CROWN CENTRAL PETROLEUM CORPORATION GENERAL OFFICES - ONE NORTH CHARLES - P.O. BOX 1188 - BALTIMORE, MARYLAND 21203		PROPOSED CROWN SITE L. ROCK RD + TUCKASEEGERE CHARLOTTE, NC	
		SITE PLAN FOR REZONING	STATION NUMBER NC-55
SCALE: 1" = 20'-0"	DATE: 8/13/98	DRAWING NUMBER *	4
DRAWN BY D.S.V.

**CHARLOTTE - MECKLENBURG
PLANNING COMMISSION
INTER - OFFICE COMMUNICATION**

SUBJECT: Administrative Approval for Petition 99-40 by CrownCen Marketing Company.

SITE PLAN FOR REZONING PROPOSED CROWN SITE
 L. ROCK RD + TUCKASEEGEE
 CHARLOTTE, NC

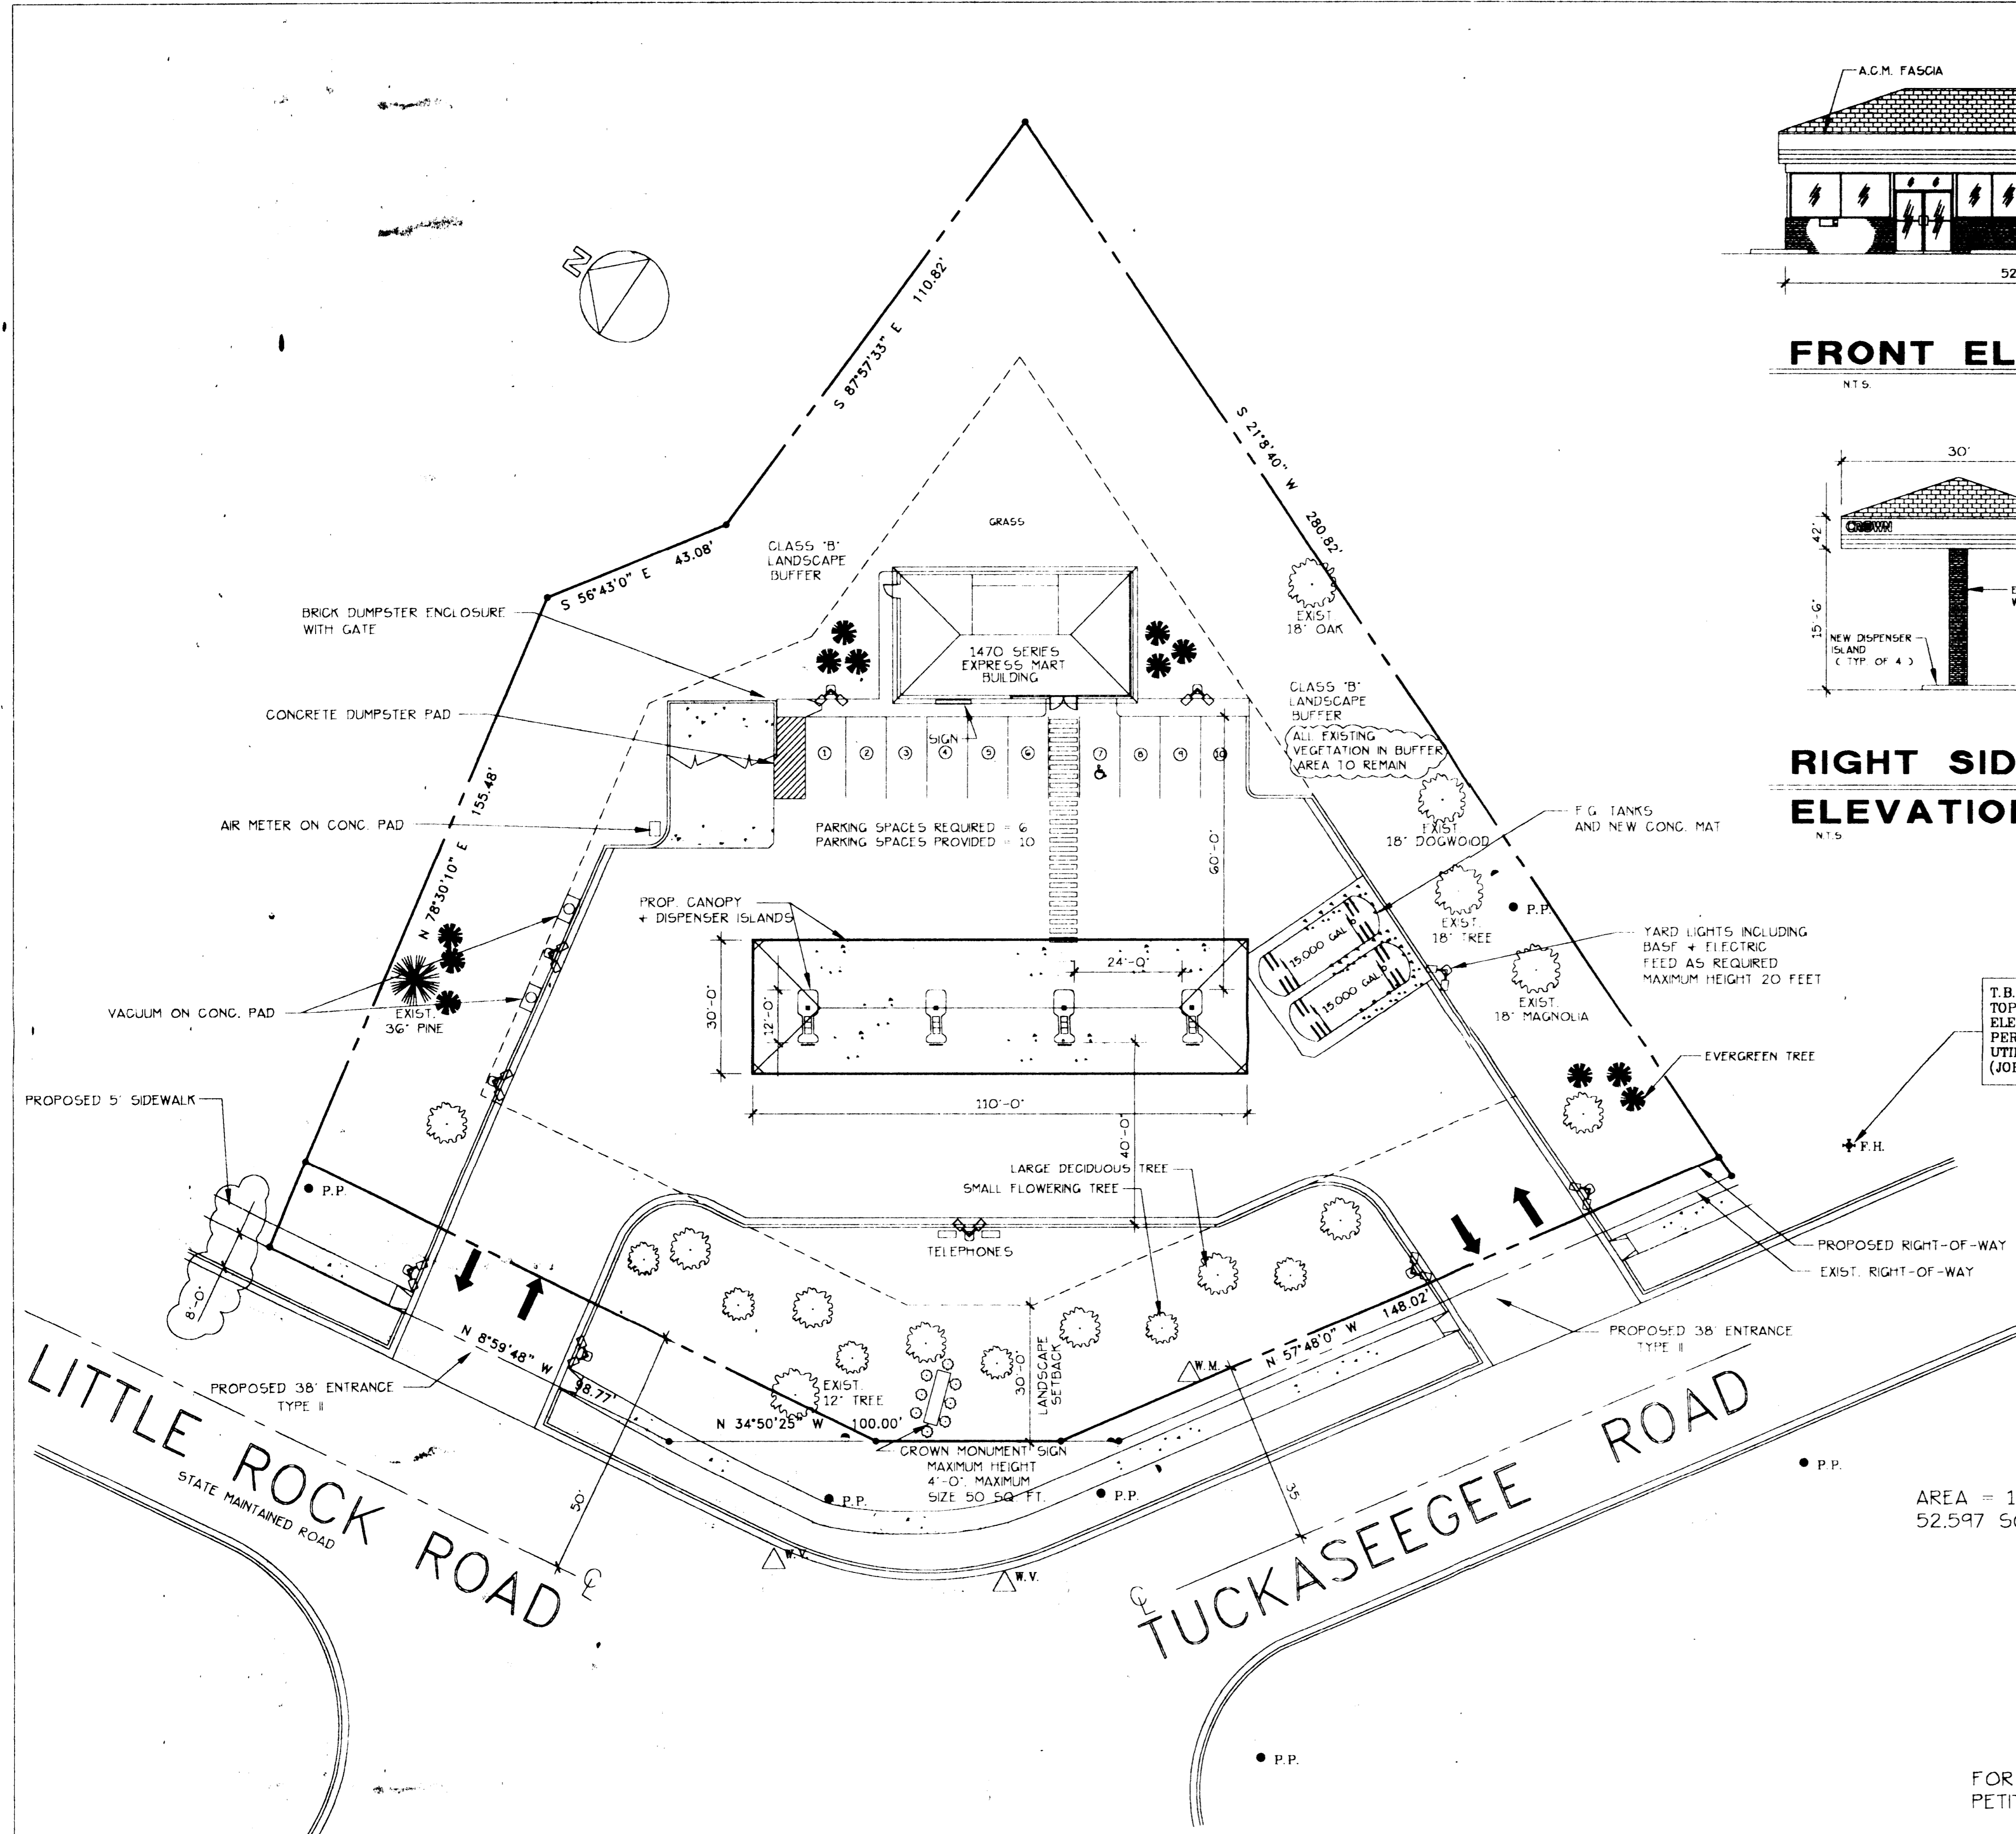
Attached is a copy of the revised plan for the above rezoning petition. The plan has been revised to slightly amend the location of the sidewalk along Little Rock Road. This is necessary to save an existing 12" caliper tree. Since this change is minor, I am administratively approving this revised plan. Please use this revised plan when evaluating requests for building permits and certificates of occupancy.
